WEST SUSSEX COUNTY COUNCIL CONSULTATION

TO:	Arun District Council FAO: Michael Eastham
FROM:	WSCC - Highways Authority: Tim Townsend
DATE:	9 November 2020
LOCATION:	Land south of Ford Lane East of North End Road Yapton BN18 0DS
SUBJECT:	Y/105/20/DOC Approval of details reserved by condition imposed under Y/80/16/OUT relating to condition 10- Construction Method Statement. More information received.
DATE OF SITE VISIT:	19 October 2020
RECOMMENDATION:	More Information Required
S106 CONTRIBUTION TOTAL:	£ See outline consent.

This is the third WSCC County Highway Authority (CHA) response to the above planning application for approval of details reserved by condition imposed under Y/80/16/OUT relating to condition 10 - Construction Method Statement (CMP). Previous CHA comments were made in response dated 19th October 2020 and 29 October 2020 and this response should be read alongside those.

LARGE TIPPER: LEFT TURN IN

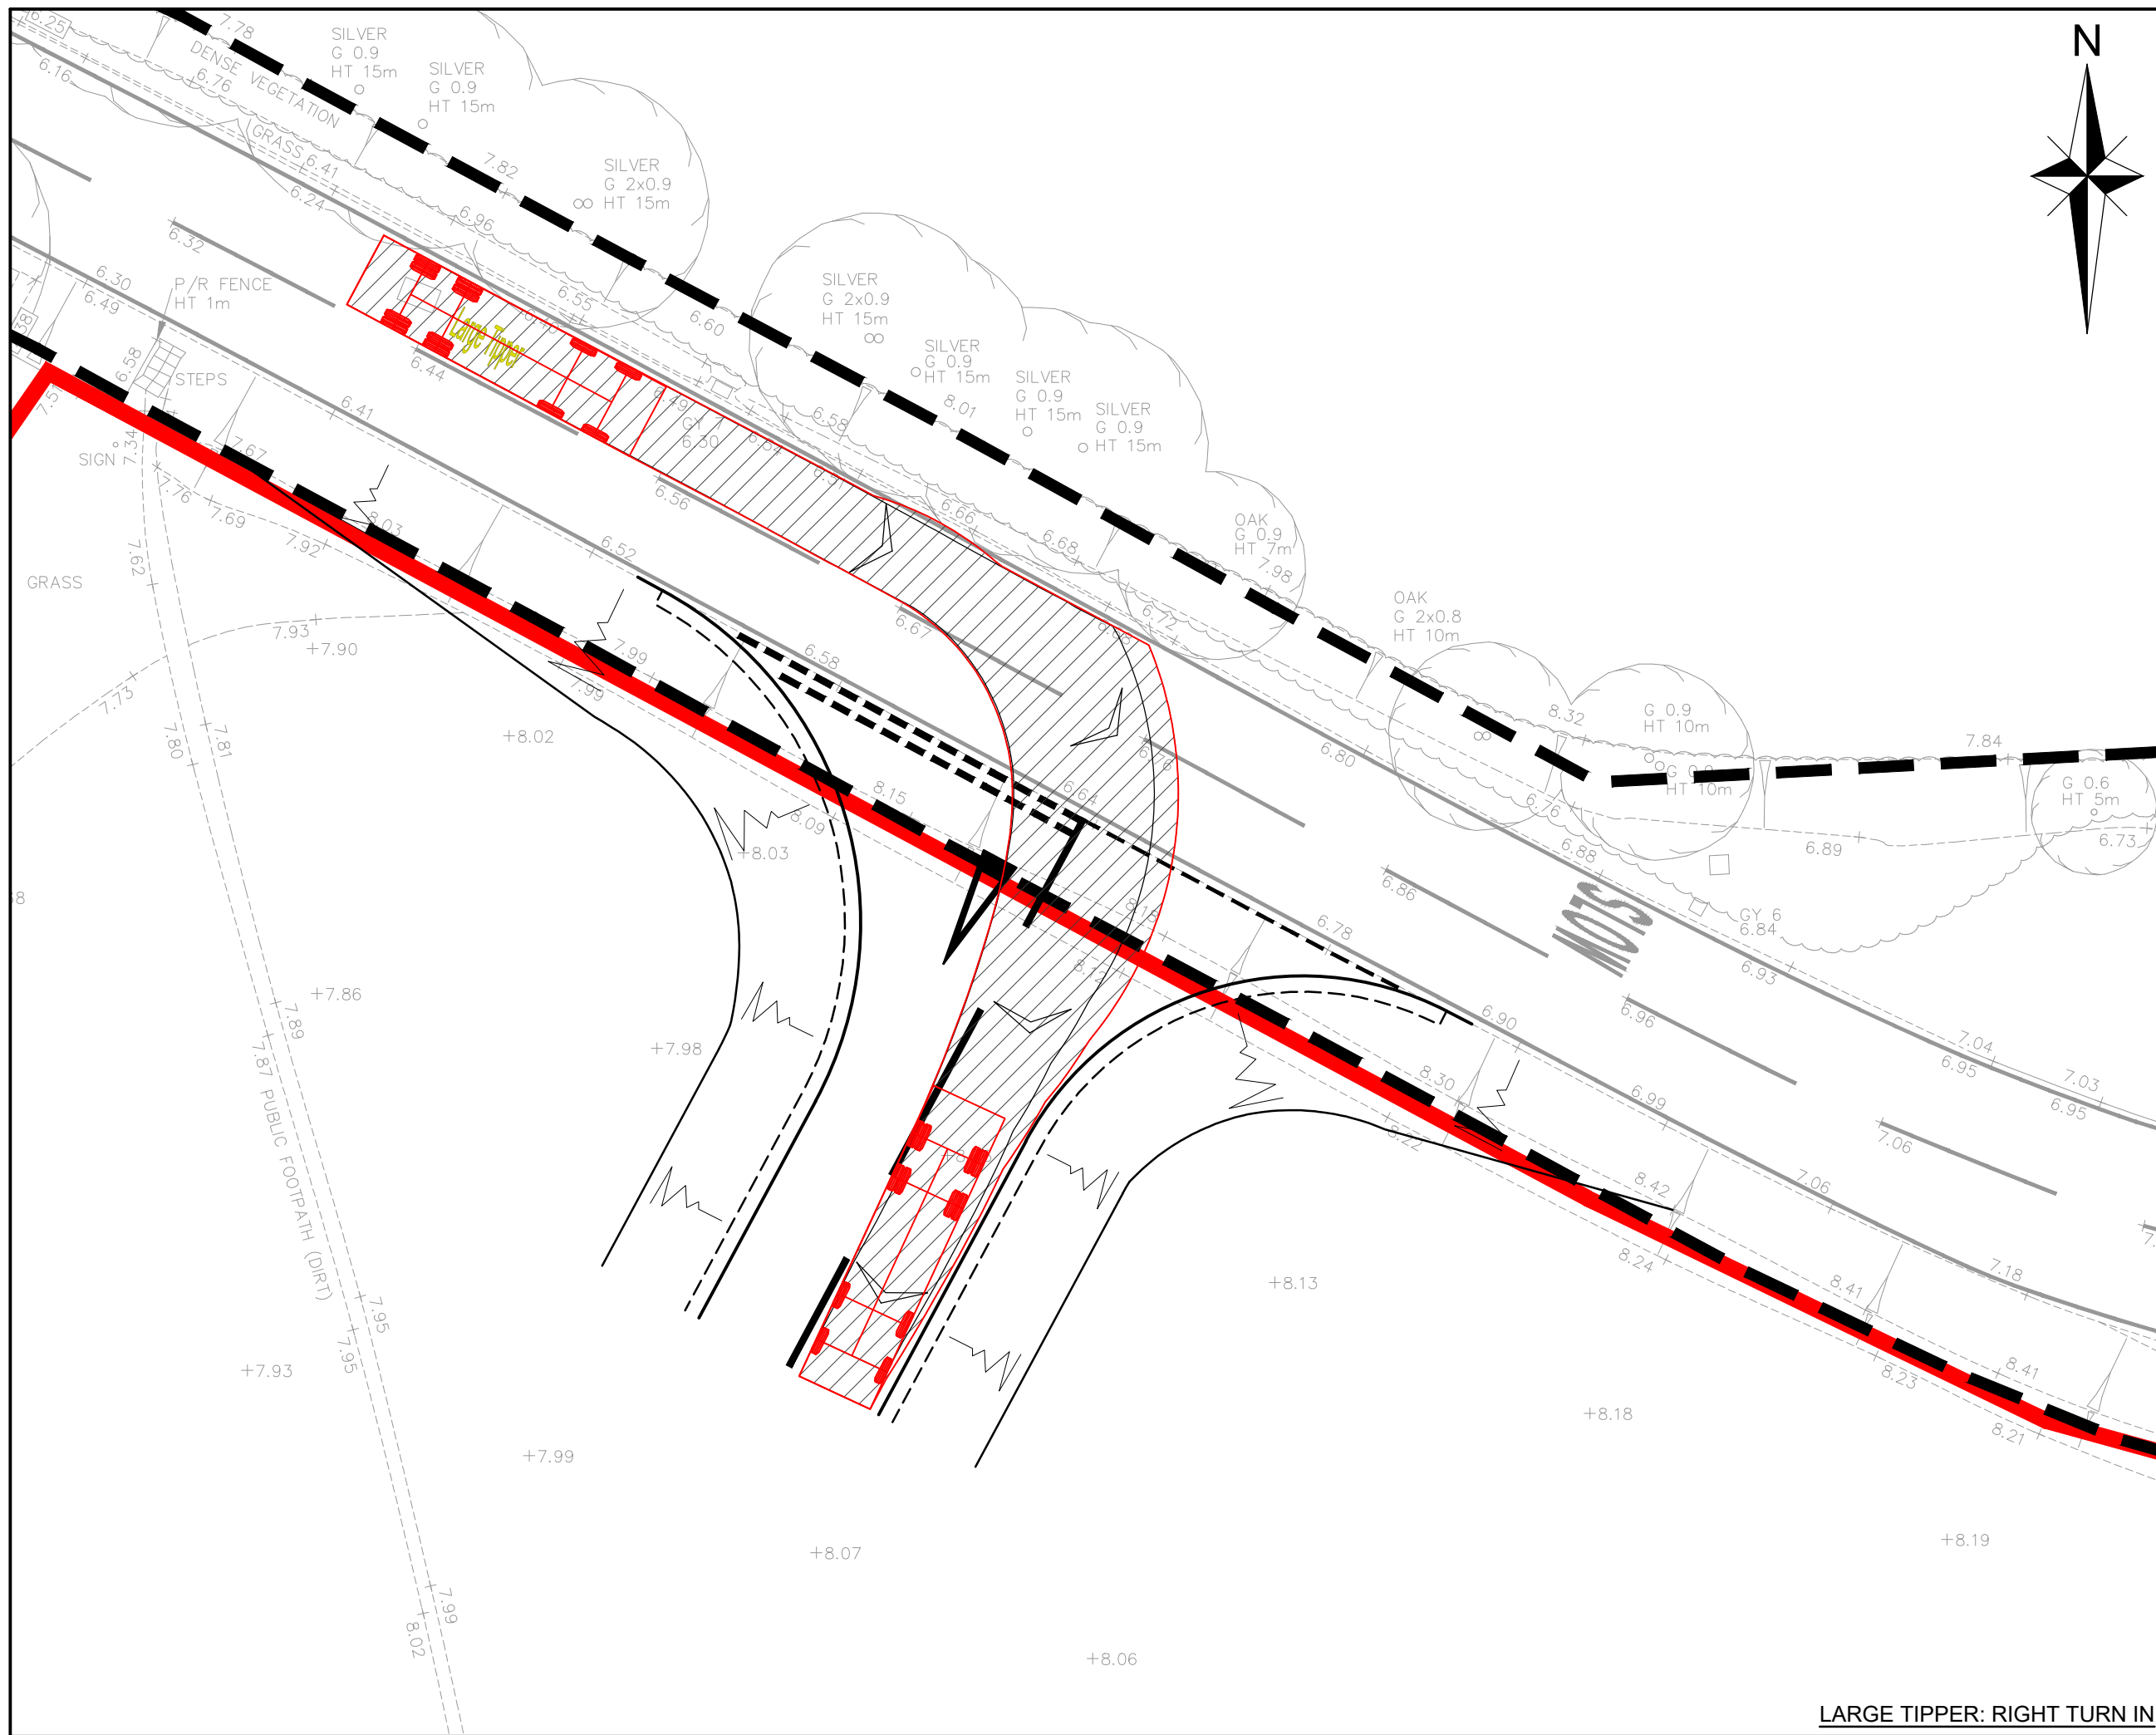
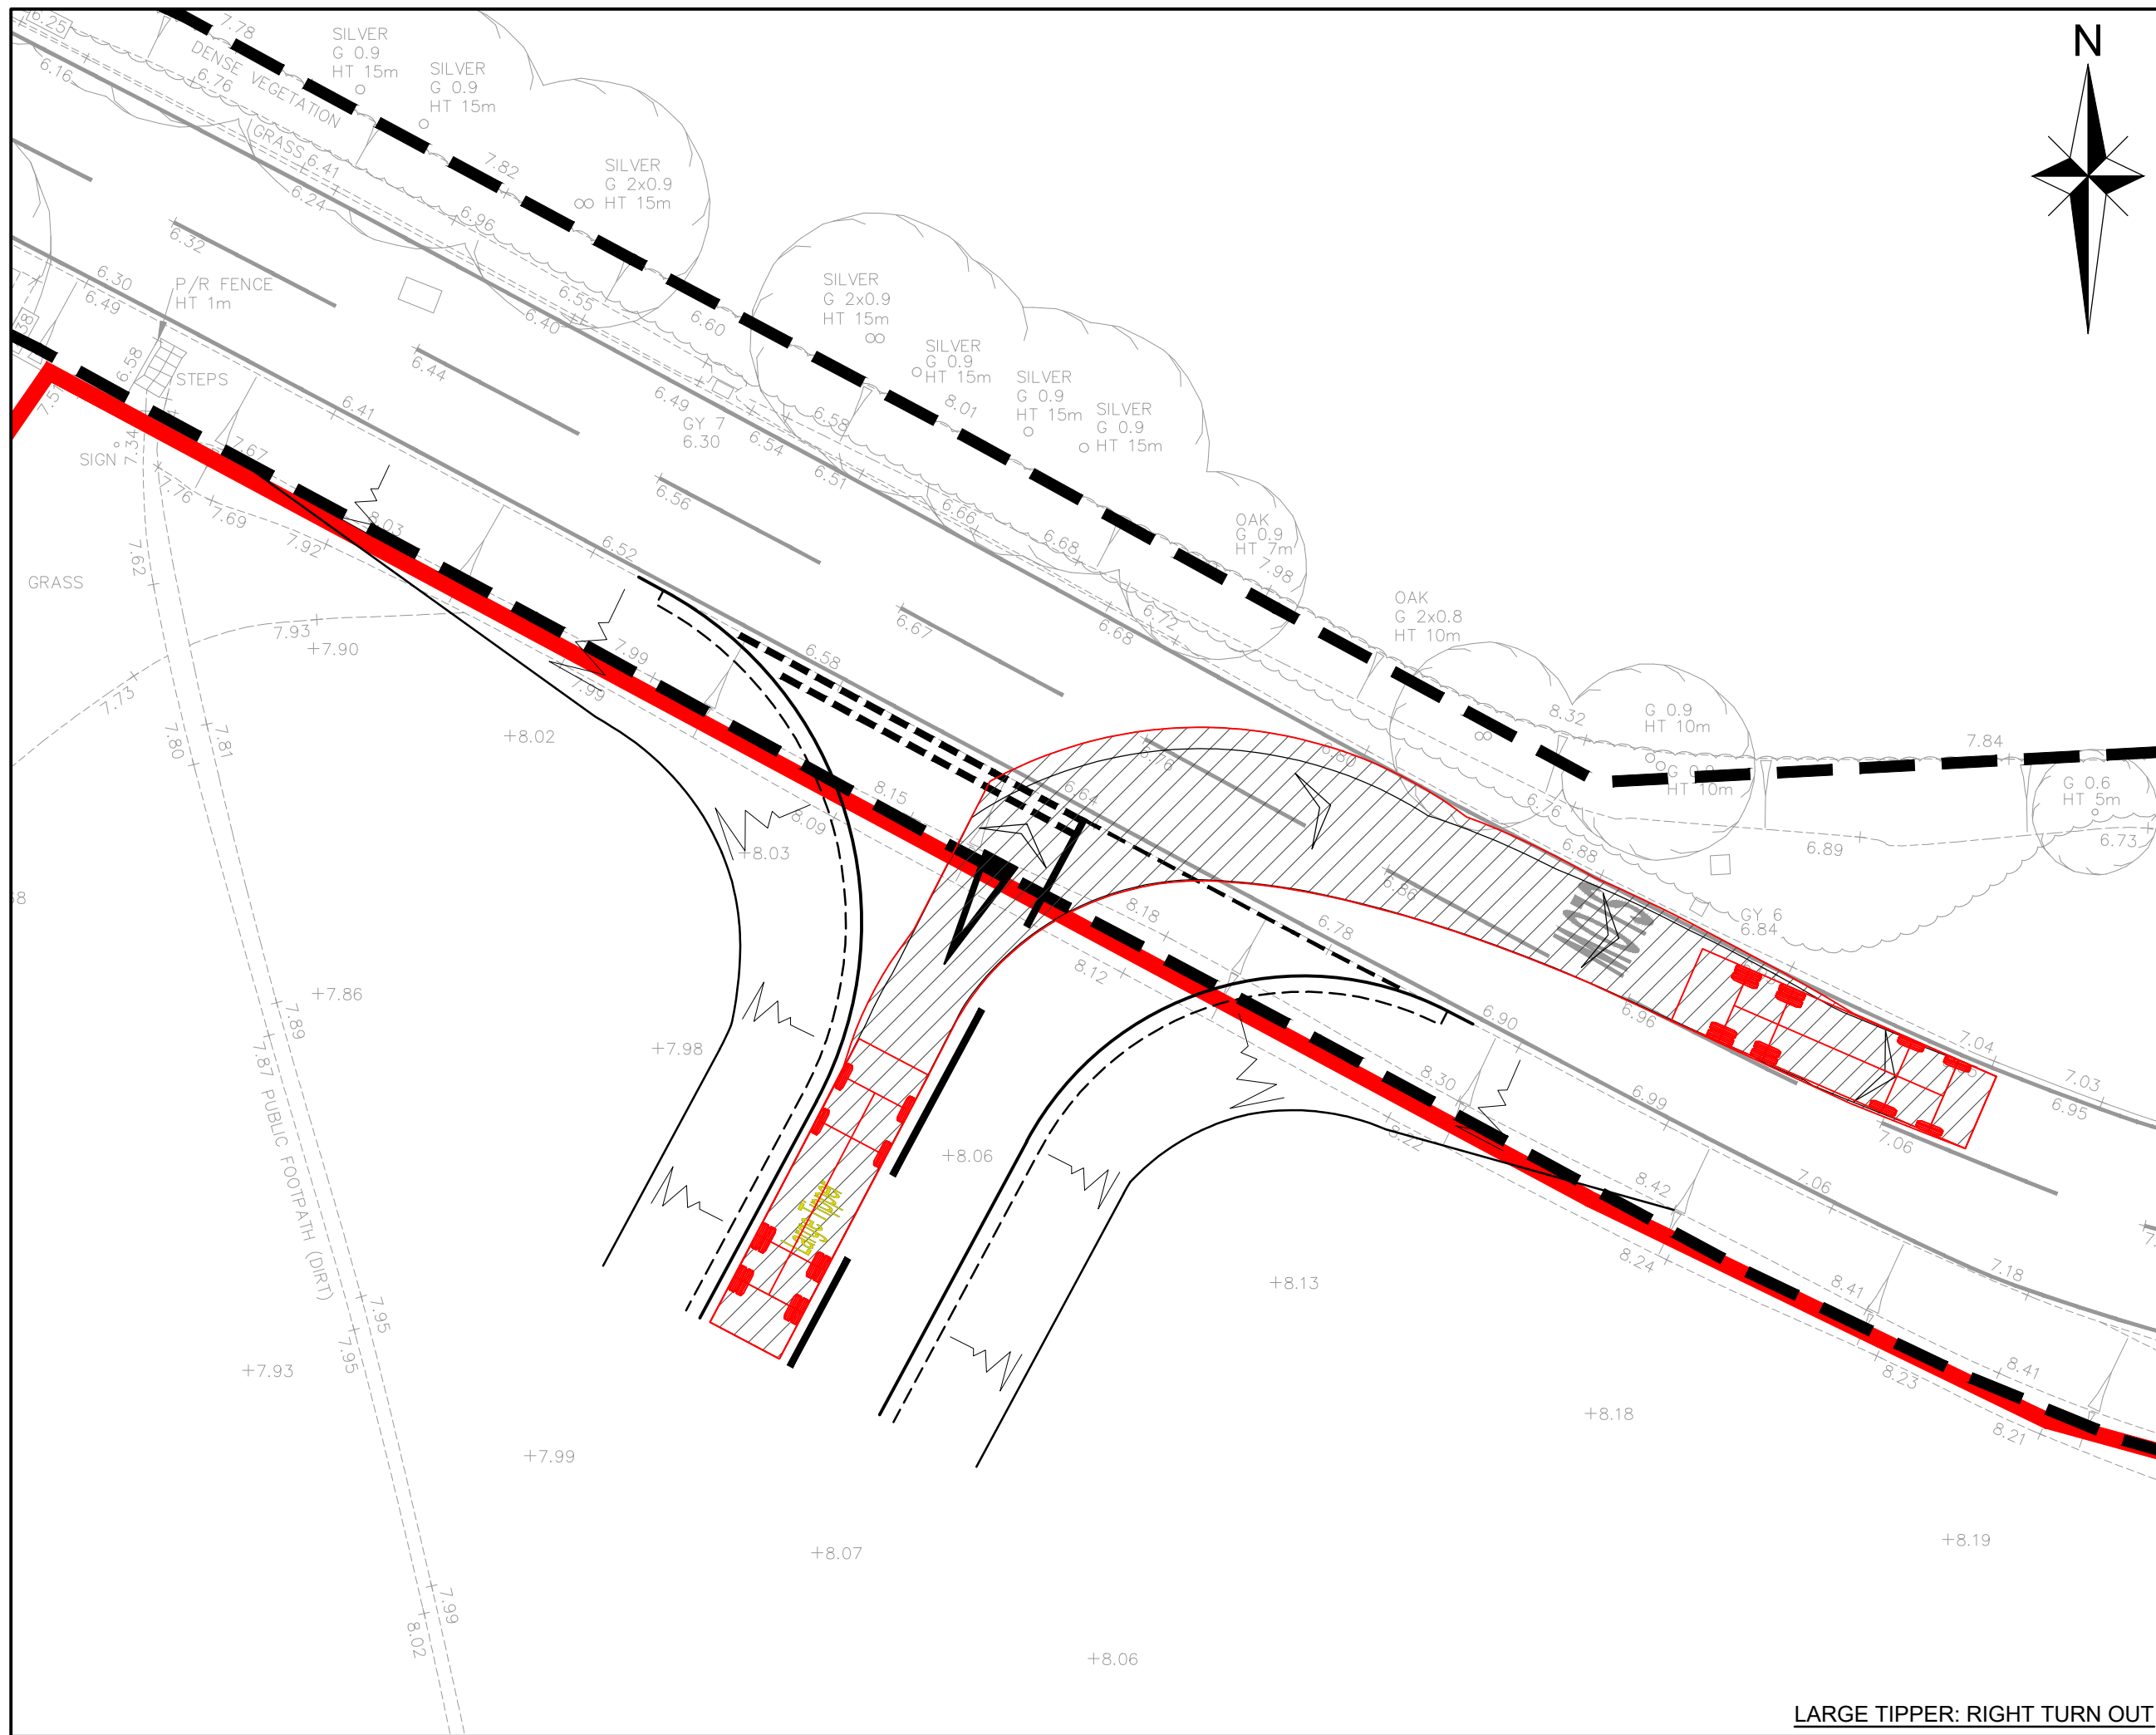
- ***‘Problem’ 3.3.1 – Risk of insufficient visibility which could lead to rear end shunt and/or side impact collisions*** – The designer’s response is not accepted by the CHA. As per the recommendation in the Safety Audit, adequate visibility is required for this access (both site access and forward visibility). Reference is still made to speed surveys taken circa 2014 (assumed to be for the main site access and NOT this temporary access), whereas a further survey has been undertaken and is

not referenced. However, consideration of the results of this latter survey do not appear to show the correct 85th percentile results (the ones listed appear too low). As such, the designer should provide further information in support of those + calculations. Visibility splays (including forward visibility splays) should then be shown on a revised plan in accordance with the results of the survey.
